## SOHT Responses to Statutory Authority Comments on SSD7881 Response to Submissions Document

### Environmental Protection Authority (EPA) letter 21/3/17

#### SSD 7881- FUNCTION CENTRE- RESPONSE TO SUBMISSIONS REPORT

RE: FUNCTION CENTRE AND RELATED WORKS (SSD 7881) – SYDNEY OPERA HOUSE – SHR 01685 - RESPONSE TO SUBMISSIONS.  
(DOC17/ 149779)

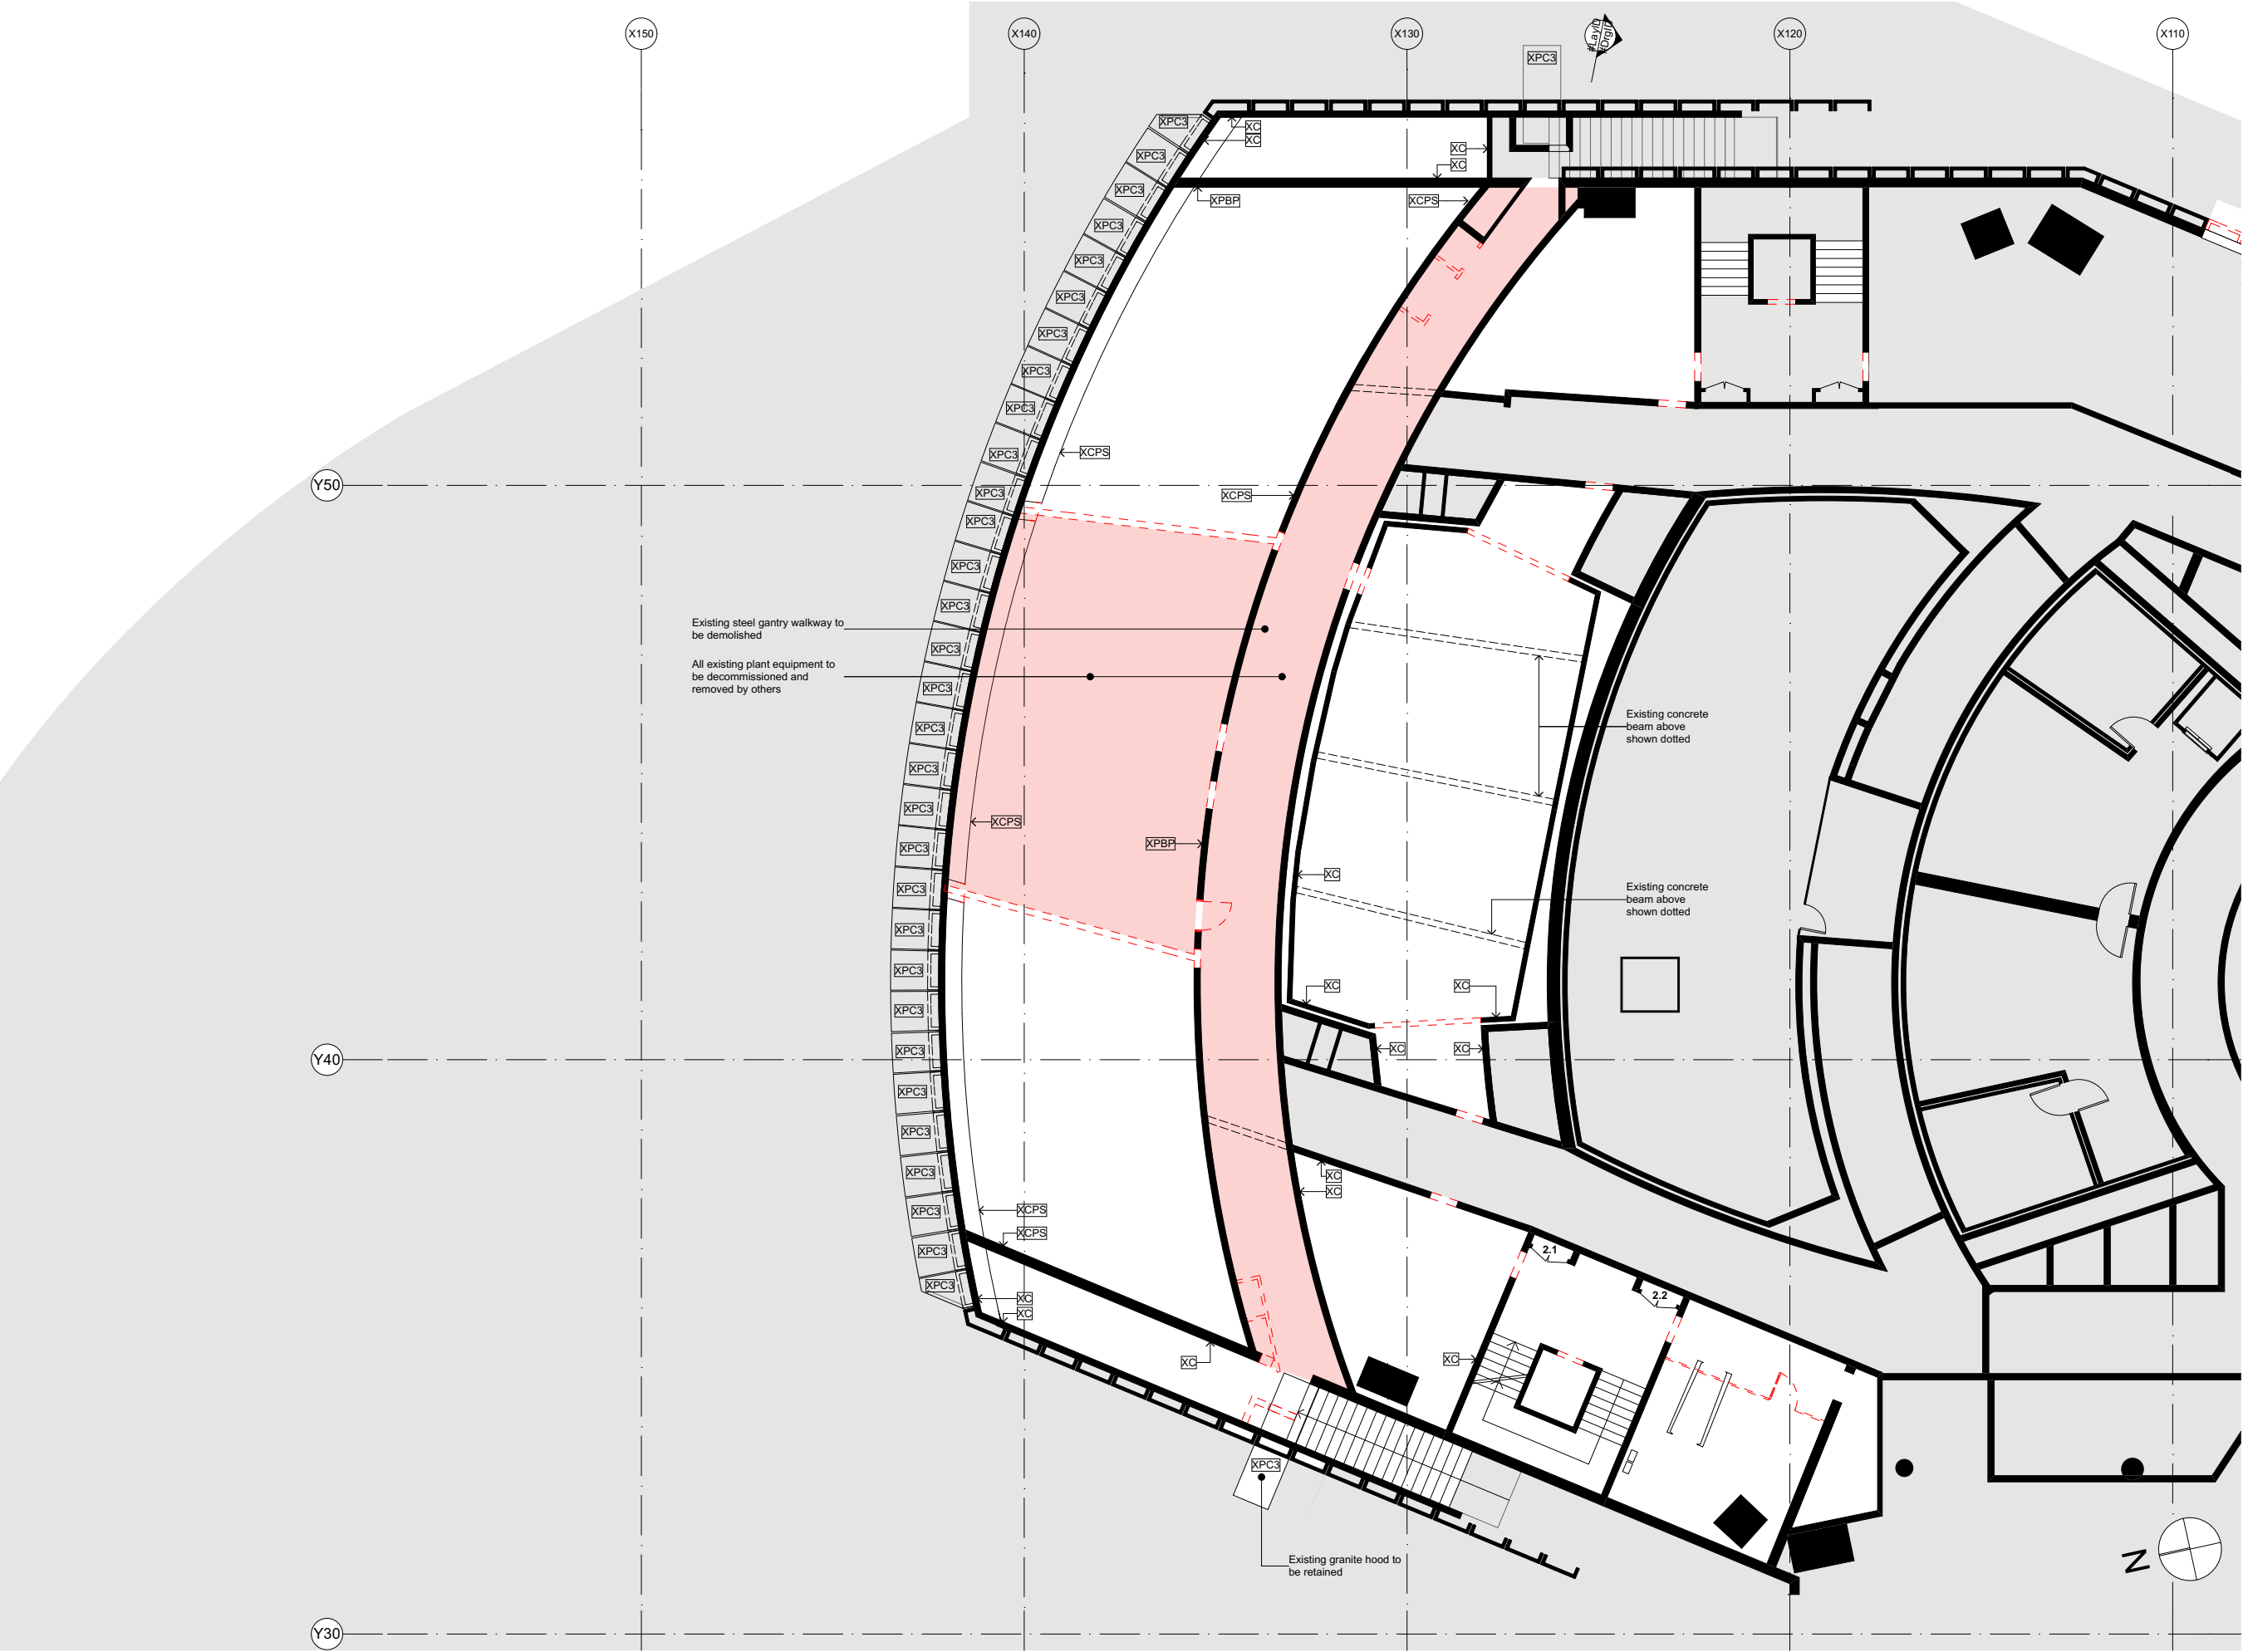
OEH Comment	SOHT Comment
<p>The original submitted drawings indicated that in order to form the three interconnected double height spaces for the function centre, demolition of the two existing concrete radial walls, which are significant structural elements of the Podium, would have been required. The entire removal of these walls would have had an unacceptable impact on the significant fabric of the Opera House. Revised documentation received 28 November 2018 indicated the partial retention of these walls, with large openings cut out of them to facilitate the connection of the spaces, and the sides and top of existing walls retained in situ. A further reduction in cut out opening sizes has been proposed and included within the RTS. Whilst this reduction does not match the extent proposed by the Heritage Council, it is considered that the applicant has demonstrated through design options that the proposed partial retention of the wall will provide clear evidence and understanding the original wall and spatial arrangement of the area.</p>	<p>Noted</p>

<p>The openings within the walls will require strengthening on one face (facing out). Should this component be approved, details must be provided outlining the proposed new work associated with the partial removal of the walls as part of the s.60 application, including details of how cut edges of the wall are finished, and details of strengthening of walls required including lintels. It is also noted that any removal of significant fabric and alteration of significant spaces will increase the significance of the Opera House's unaltered fabric and spaces.</p>	<p>Noted</p>
<p>The proposed works maintain the existing curved glass wall facing the Northern Broadwalk. External modifications comprise of two new pairs of double bronze doors and the enlargement of the existing single entry on the western side of the podium. These proposed minor works to the external façade are considered acceptable as existing materials and details will be matched and because they will facilitate access to the proposed new function area. They are also reversible. It is recommended that further details be provided with the s60 application for approval, and that building elements proposed to be removed be salvaged and stored for potential future use.</p>	<p>Noted</p>

<p><u>New works</u>  4. Additional details must be submitted as part of the s.60 application outlining proposed works associated with the cutting of openings within the two main radial walls including how the edges of the cut walls will be finished, and of strengthening required including lintel details.</p>	Noted
<p><u>New works</u>  5. Existing paint on wall surfaces proposed to be removed to expose original off-form concrete within the proposed function centre area, is to be removed in a way which does not damage or stain the original surface. Details of this process, including what product will be used to avoid staining or damaging the original surface, must be submitted as part of the s.60 application.</p>	Noted
<p><u>New works</u>  6. The proposed new doors to the function room and new hood on the western façade, are to match existing materials and details, and are to be reversible.</p>	Noted
